Case Officer: Gemma Magnuson **Recommendation:** Application Permitted

Proposal: Variation of condition 2 (plans) of 17/02373/LB - Alteration to openings

- 1.1. The Old Post Office is a detached Grade II listed building situated north-east of the village of Sibford Ferris, in the Conservation Area. Other Grade II listed buildings are situated in close proximity to the site to the east. A Public Right of Way runs adjacent to the site to the west. The site is of archaeological interest and is likely to contain naturally elevated levels of Arsenic.
- 1.2. The building became a listed building in September 1988 and is described as an early/mid 18th Century house. It is understood that it is the former post office serving the village and a post box remains in the front elevation.

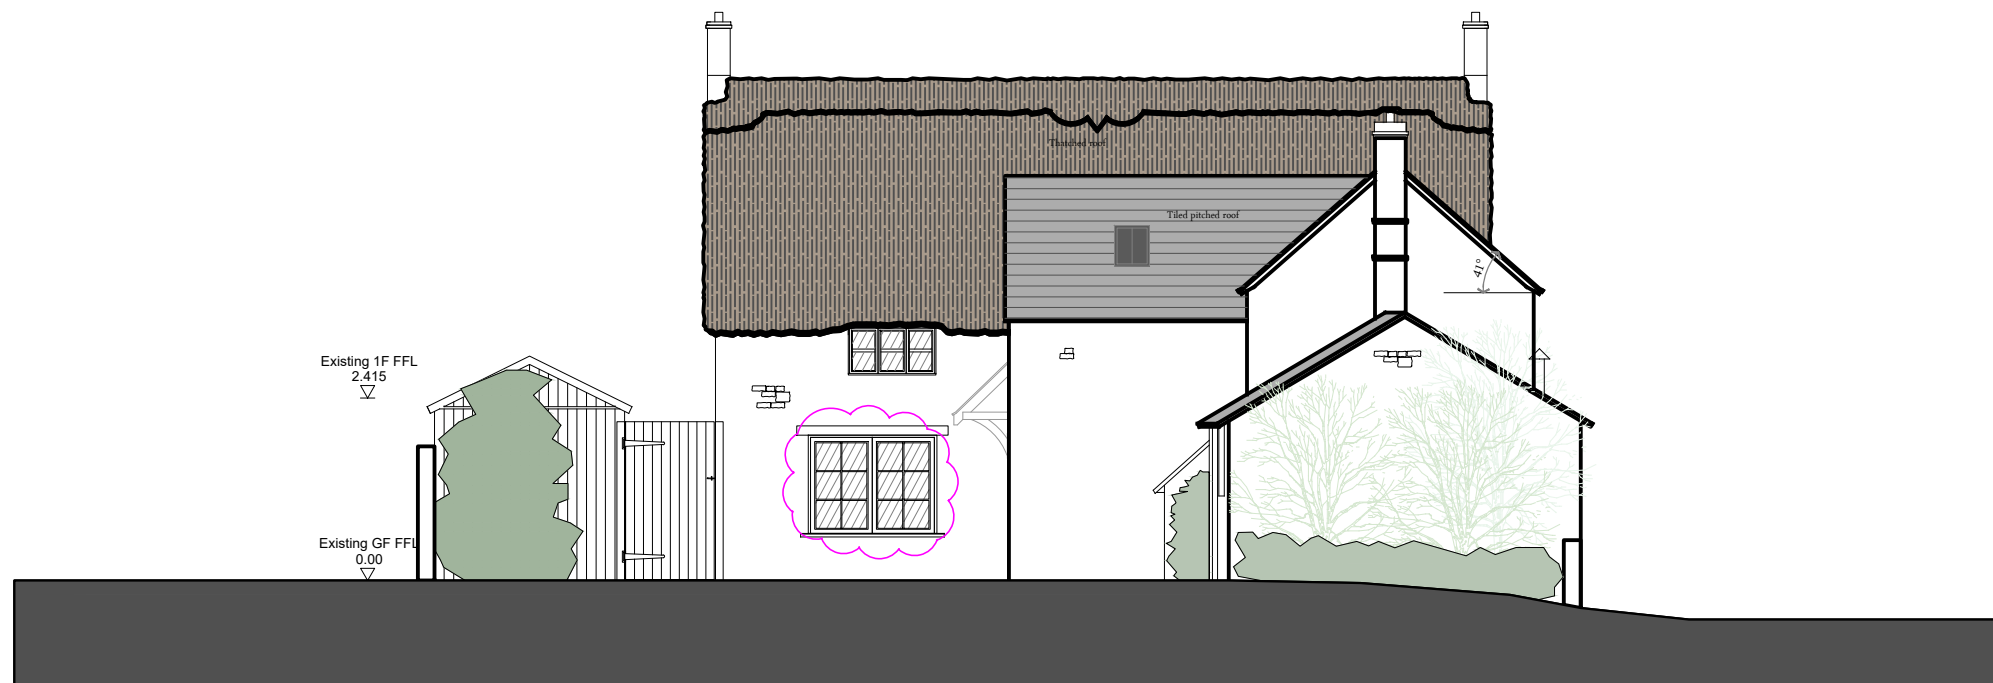
- 8.5. The principle of the development has already been accepted by the previous permission and I am therefore only considering the proposed amendments. I did have concerns regarding the original scheme, as it would involve the loss of a historic feature on the rear elevation connected to the previous post office use that is believed to have been used for loading. The style of the opening in the side of the ancillary outbuilding was also considered domestic in appearance and the increase in the rooflights on the public side of the ancillary building was considered a backwards step.

- 8.6. Amended plans were received on 15 November 2019 that included rooflights as previously approved, details of a less domestic style door and the increase in the size of an existing window opening rather than the installation of a door. This increase would actually restore the dimensions of the probable former post office loading opening and would, in my opinion, enhance its significance.

Project: The Old Post Office, Sibford Ferris, Oxfordshire, OX15	Scale: 1:20 and 1:10 @ A3
Drawing Title: Proposed Crittal Doors/Windows and Timber Barn Door	Number: 400_Rev.C

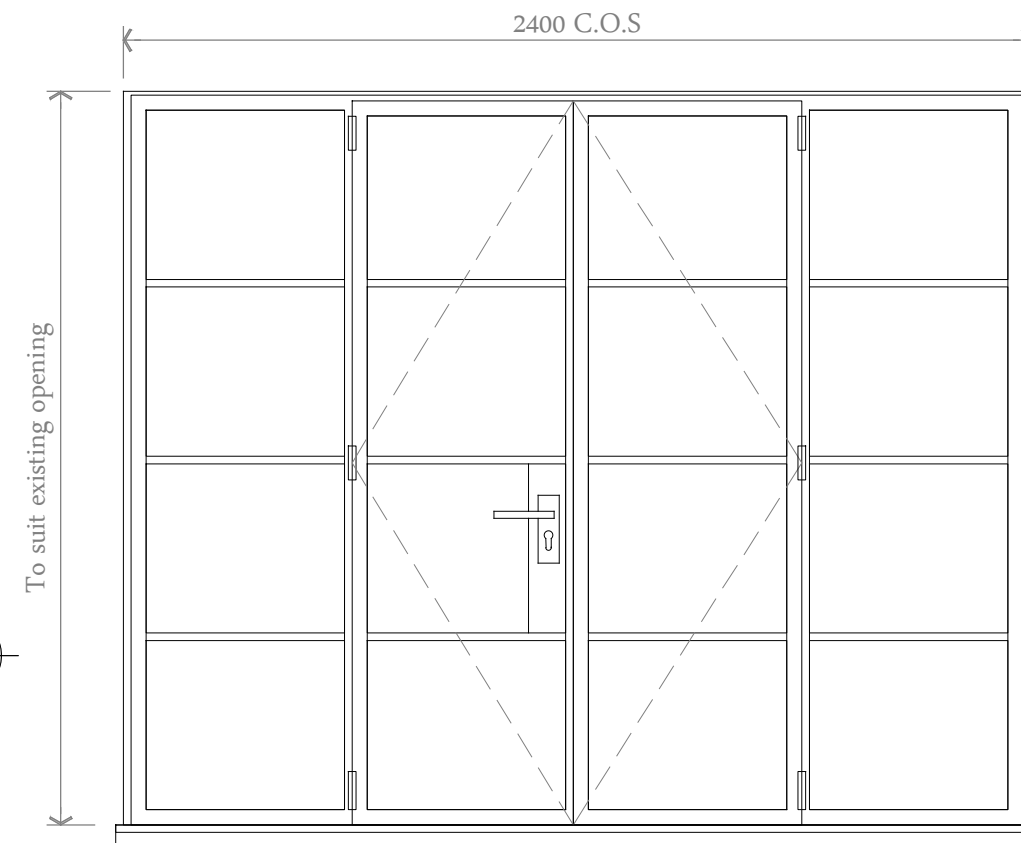
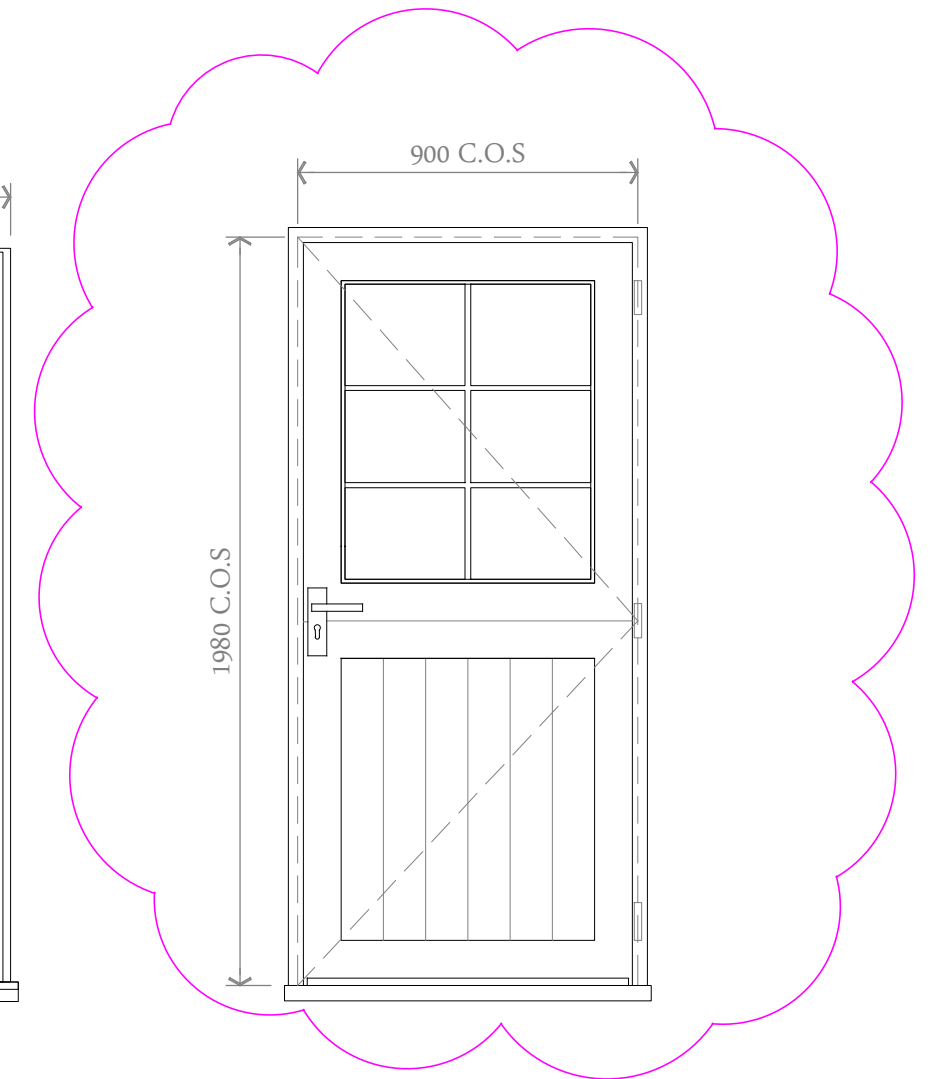
- 6.3. CDC Conservation – The general proposals are now considered acceptable. Further details are required of the proposed sections of the windows and doors. Slim lite double glazing is considered acceptable, but standard double glazing isn't. Rooflights should be flush with the slope of the roof and not situated on top of the rafters. The details can be submitted in advance of the determination of the application or can be attached as a condition. Amended plans were received on 15.11.2019 and the Conservation Officer verbally advised that these are acceptable on the same date.
